**Our Case Number:** ABP-316119-23

**Re:** DART+ South West Electrified Heavy Railway Order - Hazelhatch & Celbridge Station to Heuston Station,  
and Hesuton Station to Glasnevin  
County Dublin and County Kildare

## Observation on a Strategic Infrastructure Development Application

Figure 5-66 Cross Section at Ch 11+000 - Inchicore - Facing West

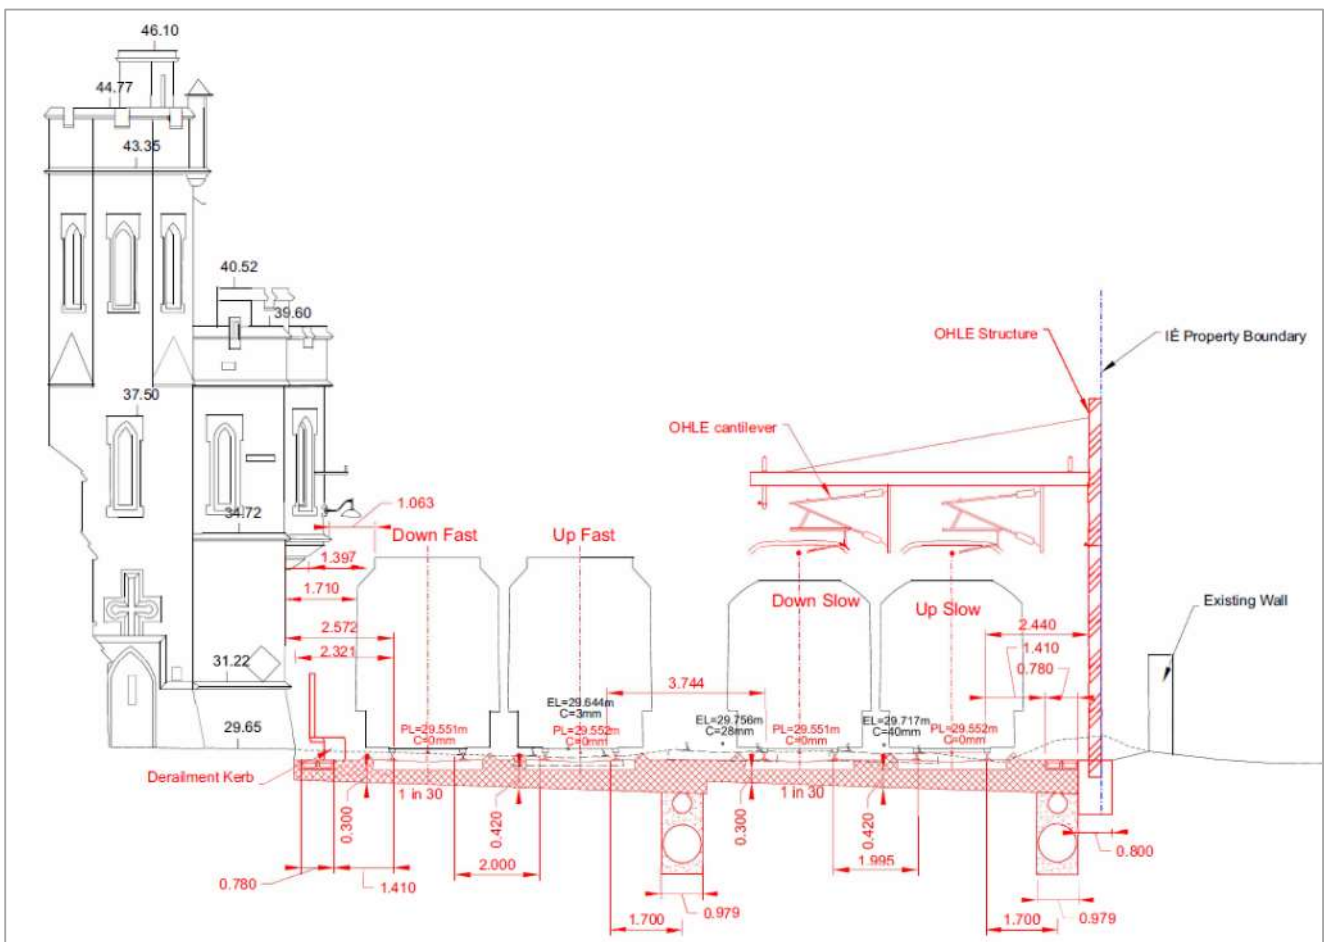
### 7. Design potentially affecting bordering properties is not complete and

seems open to interpretation. For example this excerpt from Drawing DP-04-23-DWG-RO-TTA-18984 states existing wall to be retained 'subject to detail development.' Furthermore this section does not convey the foundational work associated with the OHLE mast which is shown to sit directly on the IE property boundary.
